Recommendation Report for Planning Permission for Works or Extension to a Dwelling

REF NO: FP/156/24/HH

LOCATION: Marine View
Third Avenue
Felpham
PO22 7LN

PROPOSAL: Removal and replacement of balcony to south facing elevation.

Drawing Title: **Proposed Floor Plans and Elevations**

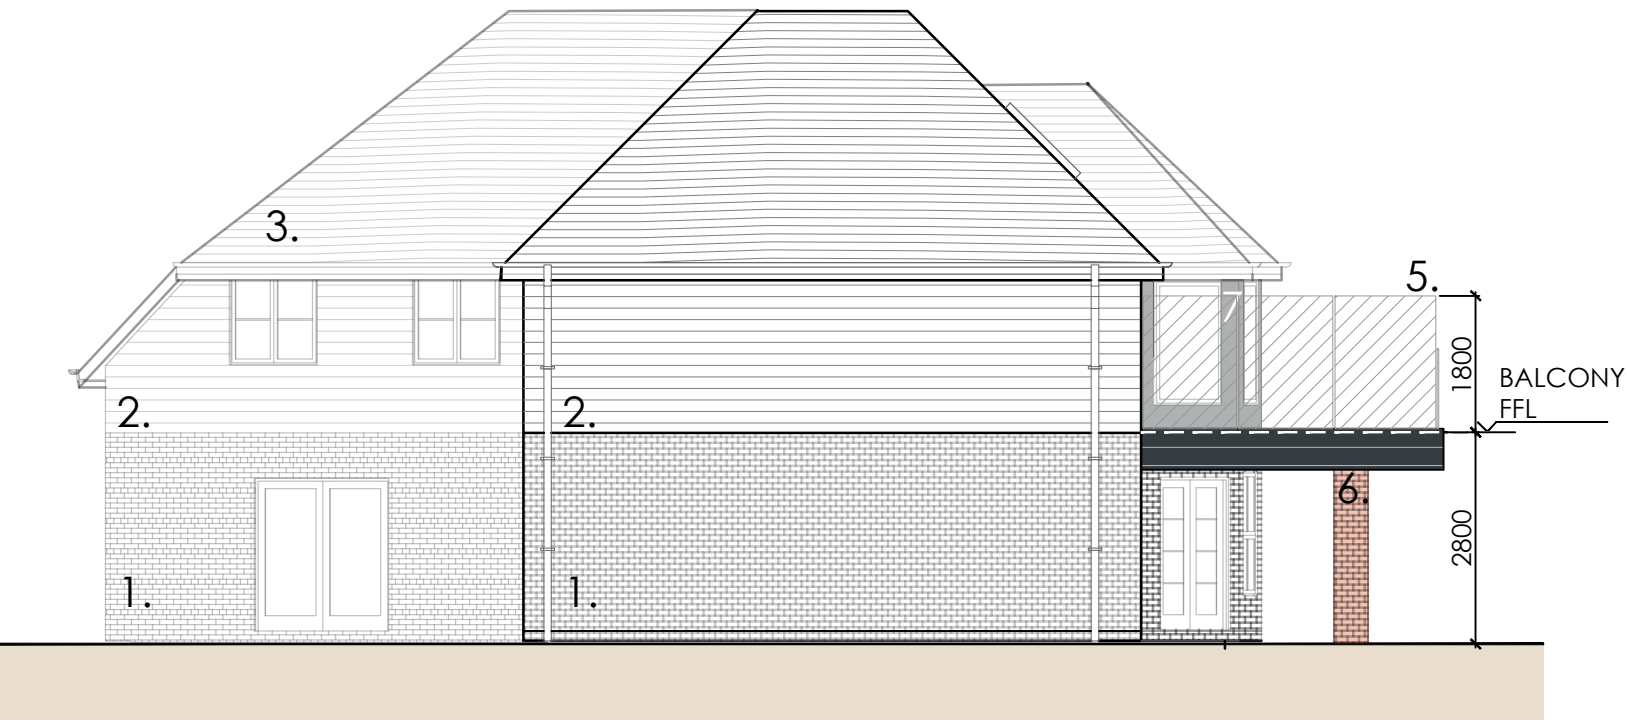
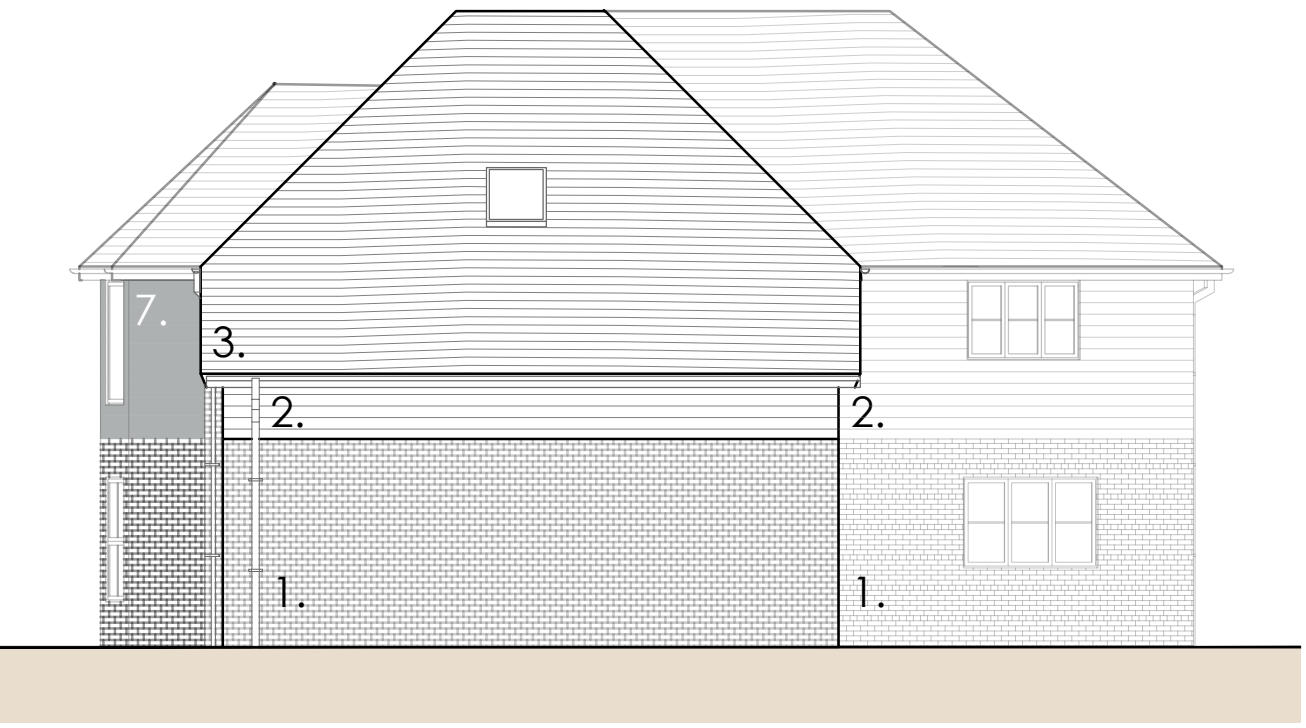
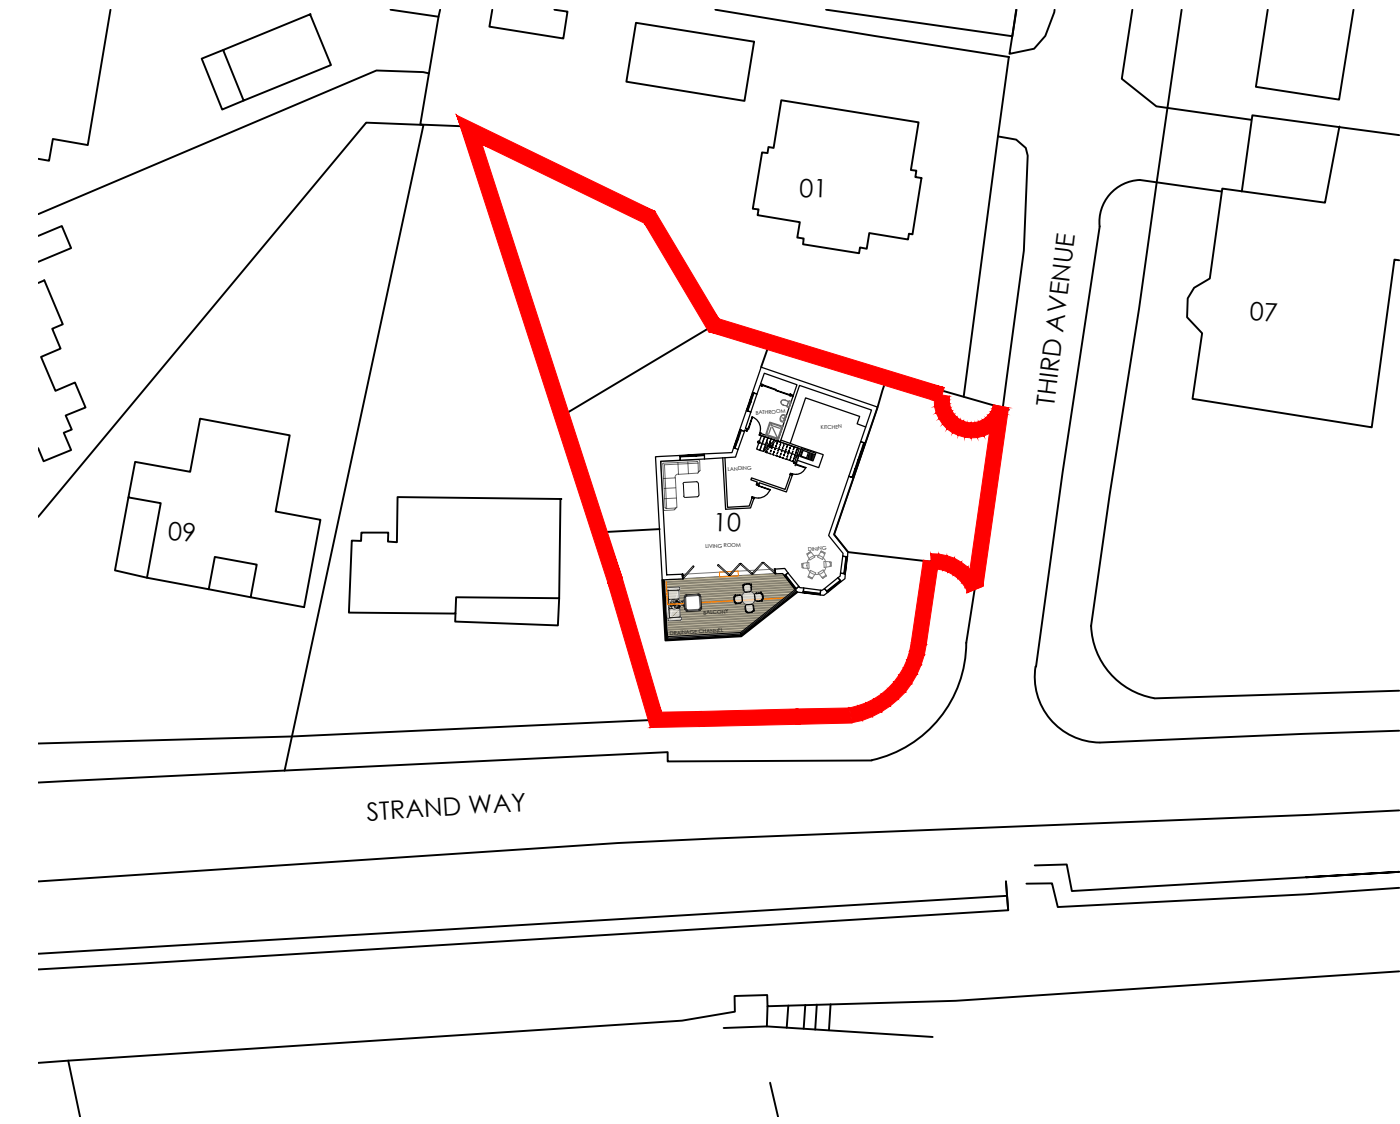
The proposed replacement balcony would have a maximum width of approx. 8m and maximum depth of approx. 4m. The proposed replacement balcony would be 2.4m deeper than the existing balcony at its deepest point. Two brick columns would support the balcony using materials to match the existing dwelling. The balcony would be set back from the front boundary by 5.4m and the balustrades of the balcony would be glazed. A 1.8m high frosted glazed panel is proposed to the western side of the balcony. Whilst it is noted that the balcony would extend approximately 1.2m closer to the front boundary than the existing front building line of the neighbour to the west, given the existing variation of dwellings when viewed from Strand Way and Third Avenue, that there is a balcony currently in situ which would be replaced by the proposed development, albeit at an increased depth, and that the balcony would be open in nature, thus it would not significantly increase the bulk and massing of the building closer to the front boundary, the balcony would not appear unduly prominent within the streetscene and would not result in harm to the character or appearance of the host dwelling.

The proposed balcony primarily provides a front facing viewpoint onto Strand Way. Strand Way is not private amenity space and as such the viewpoint provided onto this area is acceptable. However, the balcony extends forward from the front building line and as such, allows for limited side facing viewpoints. As this is a corner property, the side facing viewpoints from this balcony predominantly overlook the junction of Third Avenue and Strand Way. Whilst part of the balcony would face the

neighbouring dwelling to the east at an oblique angle, given the positioning of the balcony and the distance between the balcony and the neighbour to the east, the balcony would not overlook the amenity space serving the neighbour to the east. Furthermore, whilst the balcony would be sited a minimum of 2.1m from the western boundary, the balcony would not overlook this neighbour given the provision of a 1.8m high frosted glass screening along the entire depth of the balcony to the western side.

3 The materials and finishes of the two pillars/columns and cladding to the south and east elevations of the first-floor turret hereby permitted shall match in colour and texture those of the existing building.
